**Application Reference:** 2025/0550

**Site Address:** 2 Pagnell Avenue, Thurnscoe, Rotherham, S63 0RF

**Introduction:** This application seeks full planning permission for the erection of a two storey side extension

DRAWING No :
MS/77/25
- 02 A

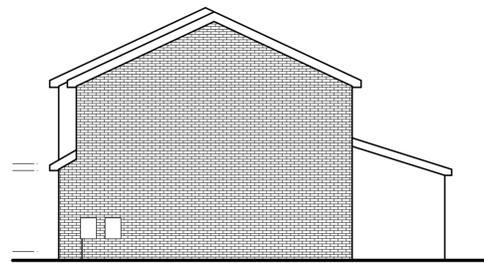
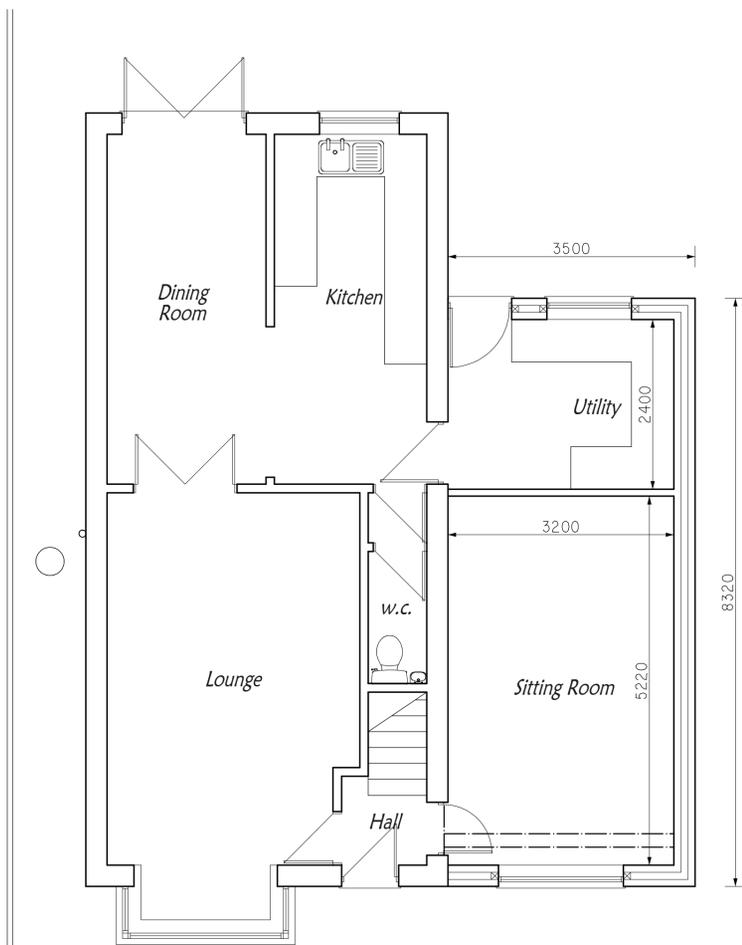
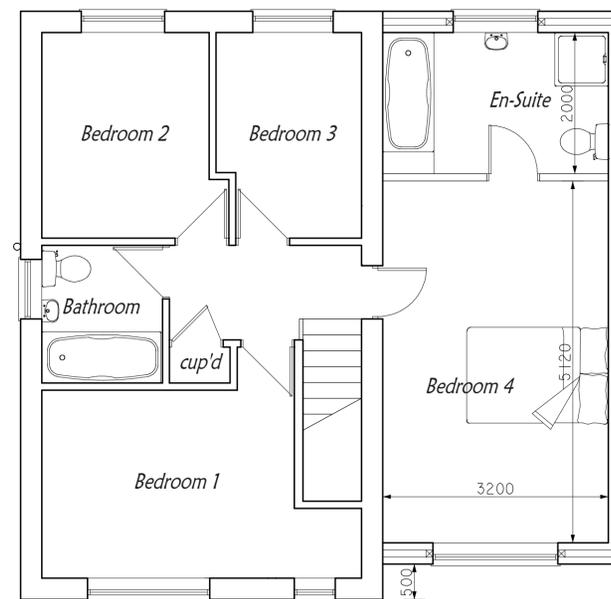
The proposal is for a typical style of two storey extension. Following a request, the proposal was amended to meet the scale and design requirements outlined within the SPD House Extensions and Other Domestic Extensions. The extension now features a first floor set back, a step down of the roof, and most significantly, the width of the side projection is now less than half of the average width between the original side elevation and diagonal boundary treatment. Additionally, the width of the extension is now also less than two thirds of the width of the original dwelling. With the existing detached garage proposed to be removed to make way for the extension, this somewhat reduces the impact proposal by being located closer to the host dwelling, With the proposal set within adequate curtilage and meeting local policy requirements, it would be considered to have a limited impact on the scale, design or character of the dwelling, in accordance with Local Plan Policy D1.

Matching materials of brick, roof tiles and UPVC windows are proposed, which along with a set back of the first floor and step down of the roof would replicate the existing dwelling whilst also showing subordination to the host dwelling. As the overall design of the proposal is that of a typical two-storey extension, and is compliant with local policy, its impact upon the scale, design and character of the dwelling, and broader street scene would be considered as limited.

PROJECT:	DOUBLE STOREY EXTENSION	
ADDRESS:	2 PAGNELL AVENUE THURNICOTE ROTHERHAM	DRAWING No: MS77/25 - 02
CLIENT:	MR BRIGGS & MISS ELLIAS	SCALE: 1:50 & 1:100

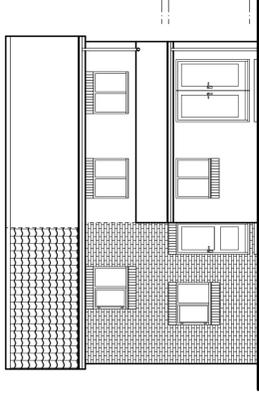
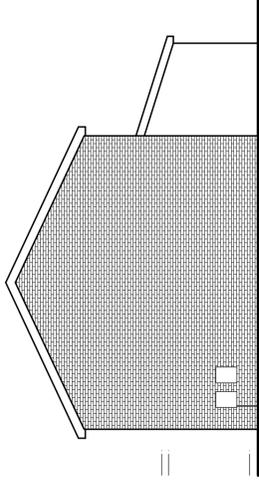
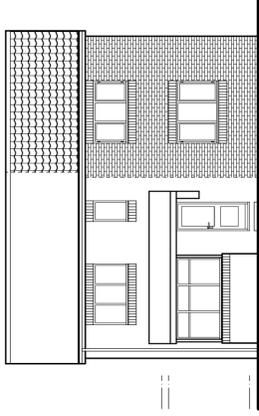
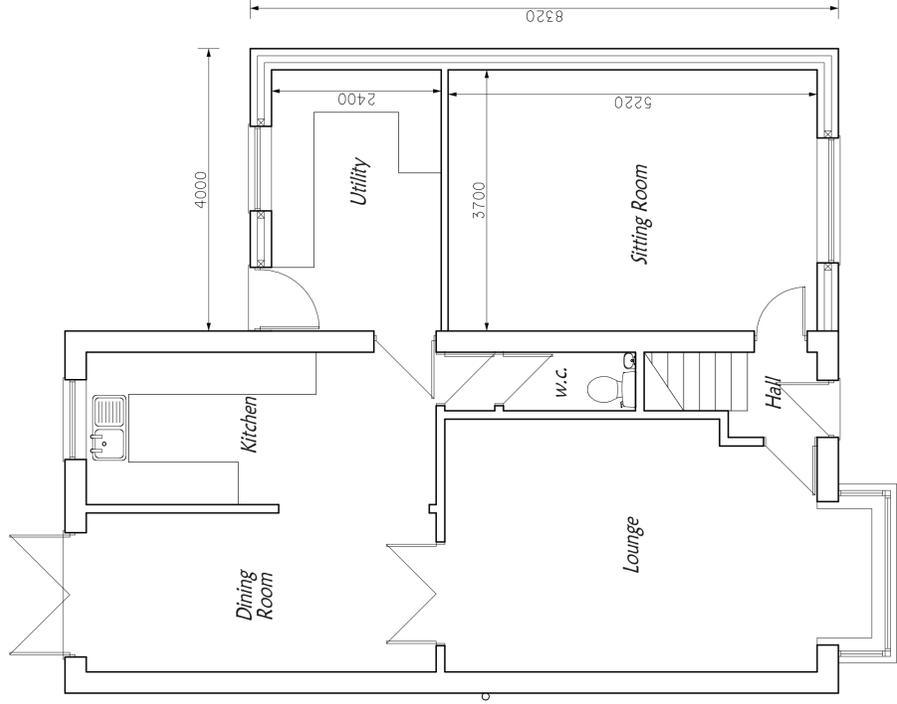
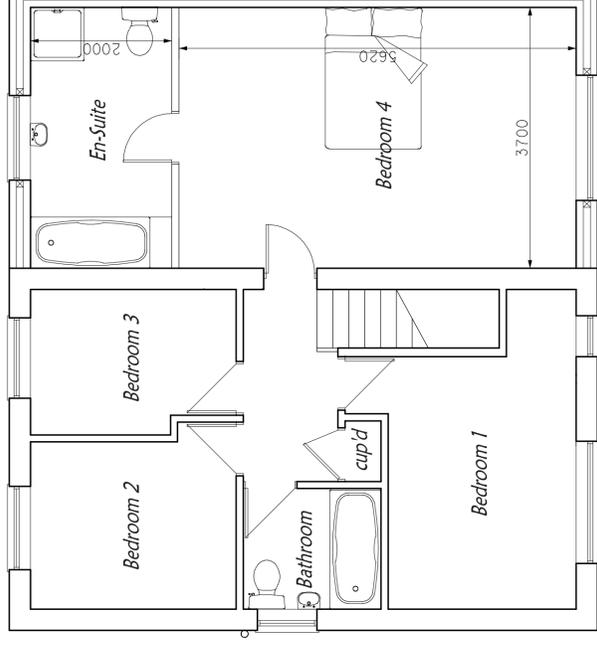
- The original plans for the extension proposed a side projection of 4m and featured no set back or step down of the roof.
